A46 Newark Bypass

TR010065/7.38

November 2024

**7.38 TABLE OF ERRATA - TRACK CHANGED**

Viewpoint 18: View north-west from Newark Castle representative of views for visitors to the castle and gardens.

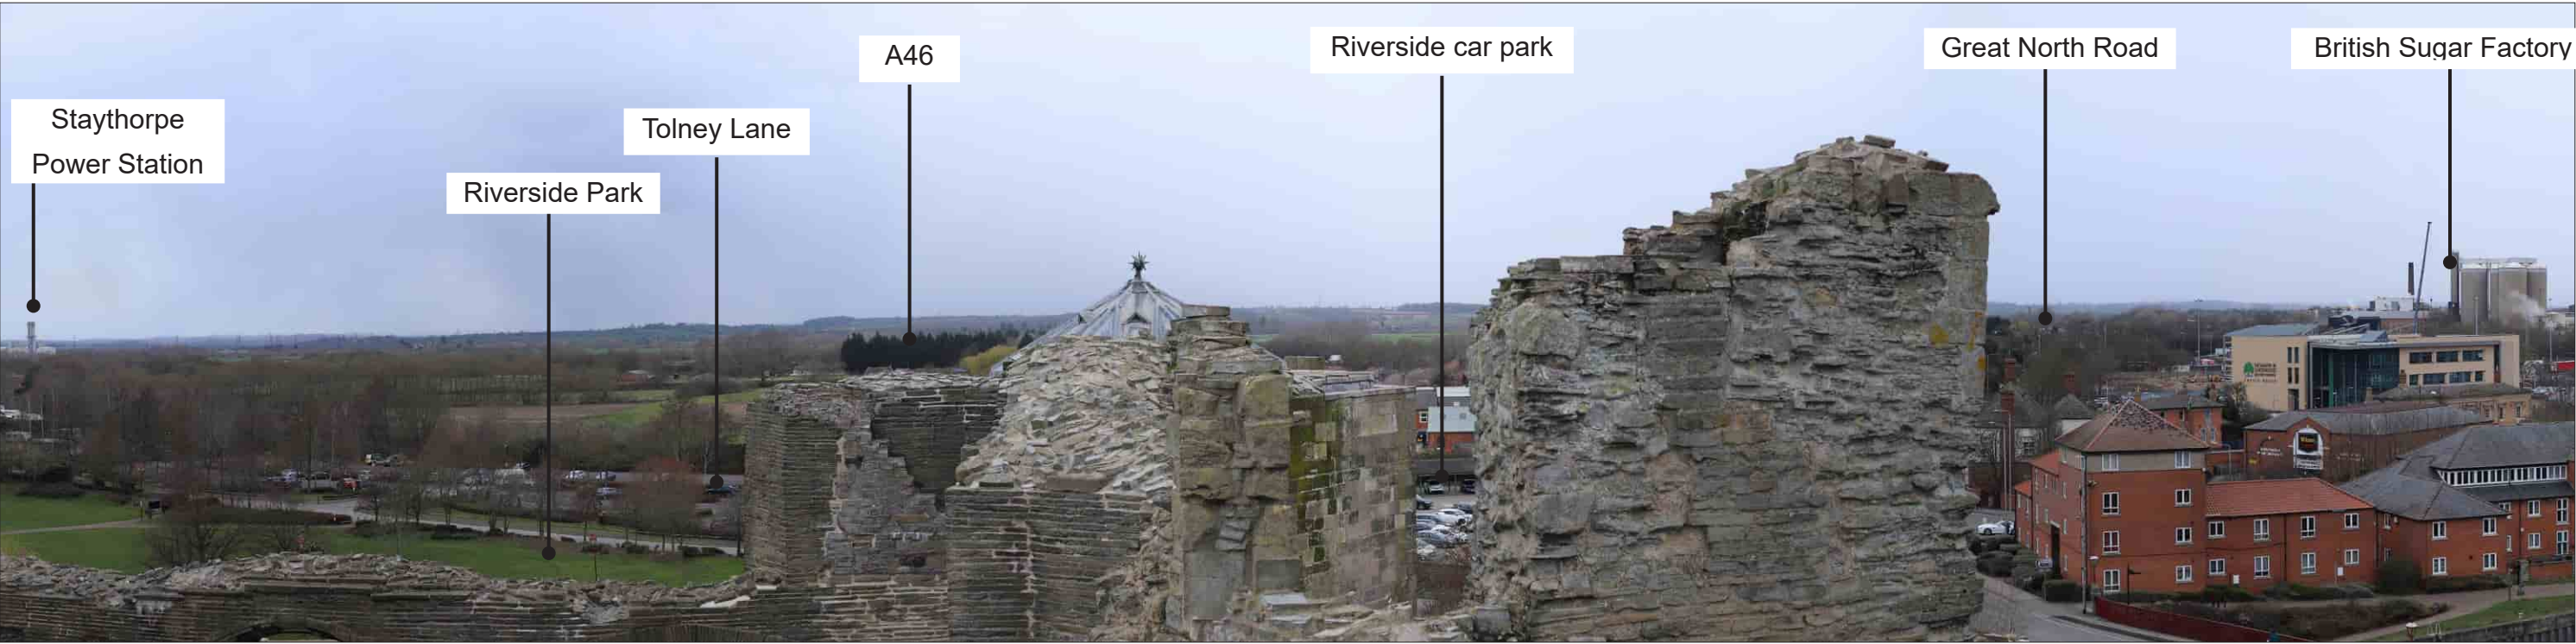
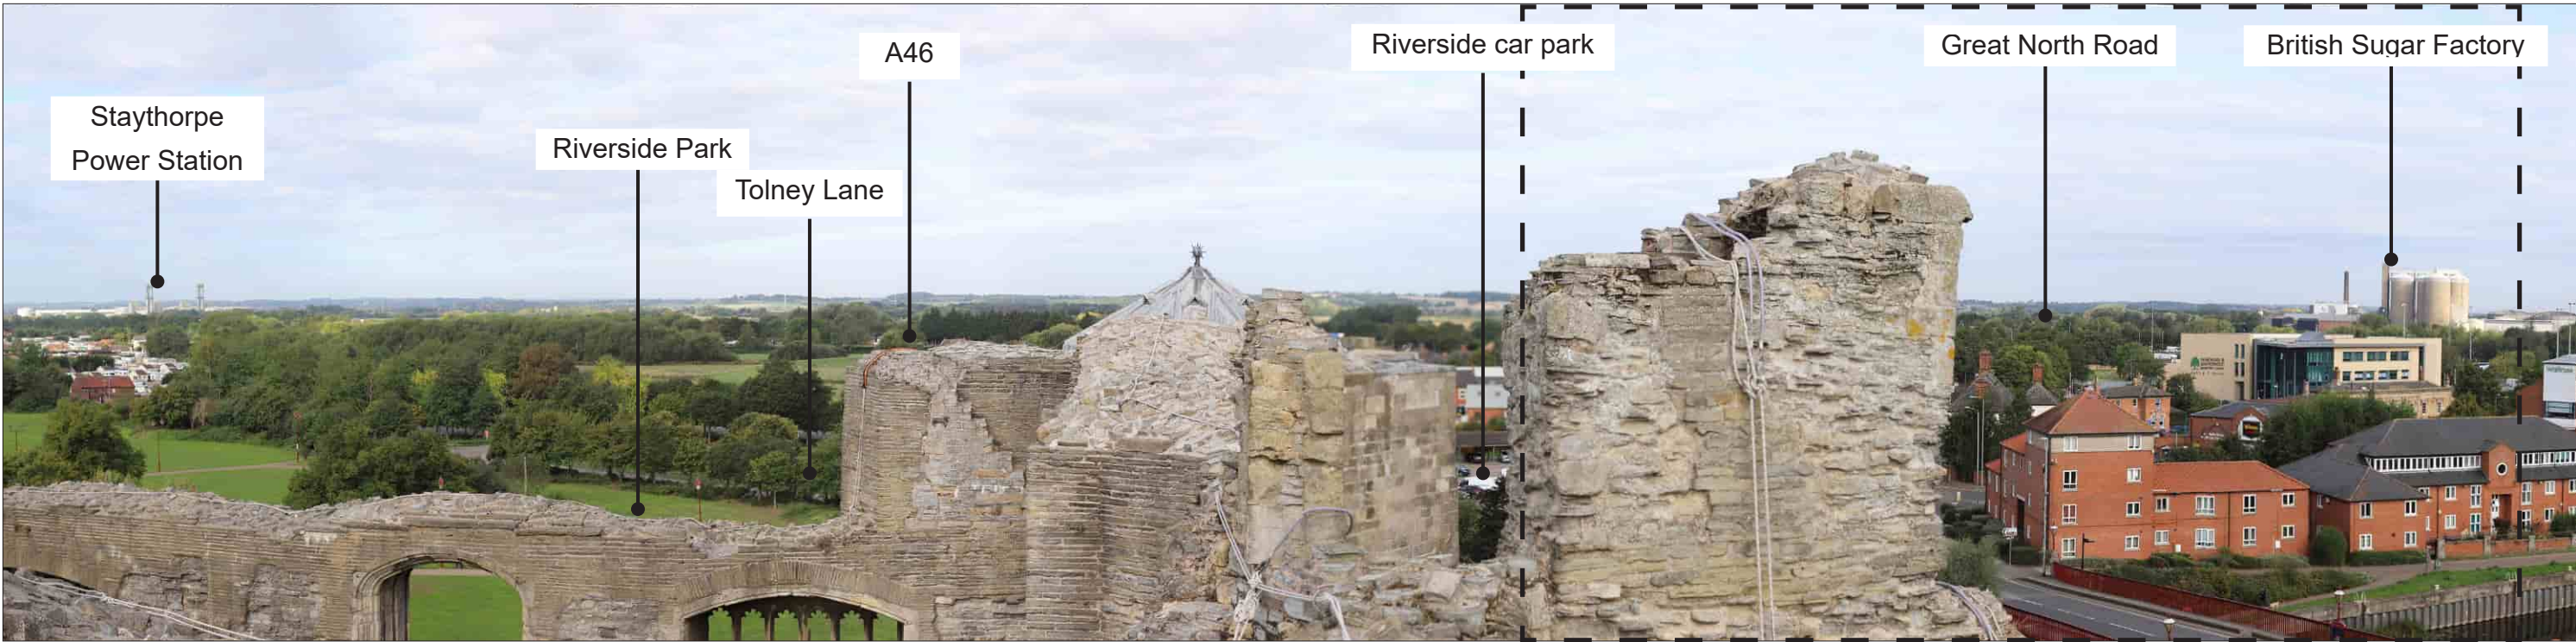
6.2.1	APP-138	Appendix 7.3 (Key Visual Receptor Photographs and Photomontages Part 1) of the Environmental Statement Appendices	16	Viewpoint 18: View north-west from Newark Castle representative of views for visitors to the castle and gardens	Identified by NSDC in RR-048	Spelling error	Applicant confirmed in response to relevant representations that the label on Viewpoint 18 should read " <b>Staythorpe Power Station</b> ", not " <del>Stanhope Power Station</del> ".
